**PAVEMENT DESIGN REPORT  
TRAILS AT ASPEN RIDGE, FILING NO. 3, PHASE 2  
LAZY RIDGE DRIVE  
EL PASO COUNTY, COLORADO**

**PCD File No. SF2122**

April 24, 2026

**Exhibit 4: Recommend Mechanically Stabilized Subgrade Pavement Section**

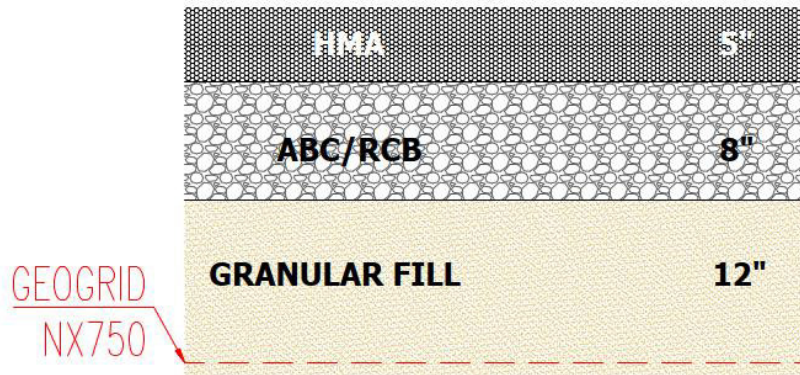
Please include a statement on the subgrade below the geogrid. Is the subgrade being scarified and compacted in this case after the overex? This section just needs to be a little more clear.

clarify if this is the existing subgrade and import or just the import layer.

uncompacted existing subgrade wouldn't pass a proof roll if that is what is being expected.
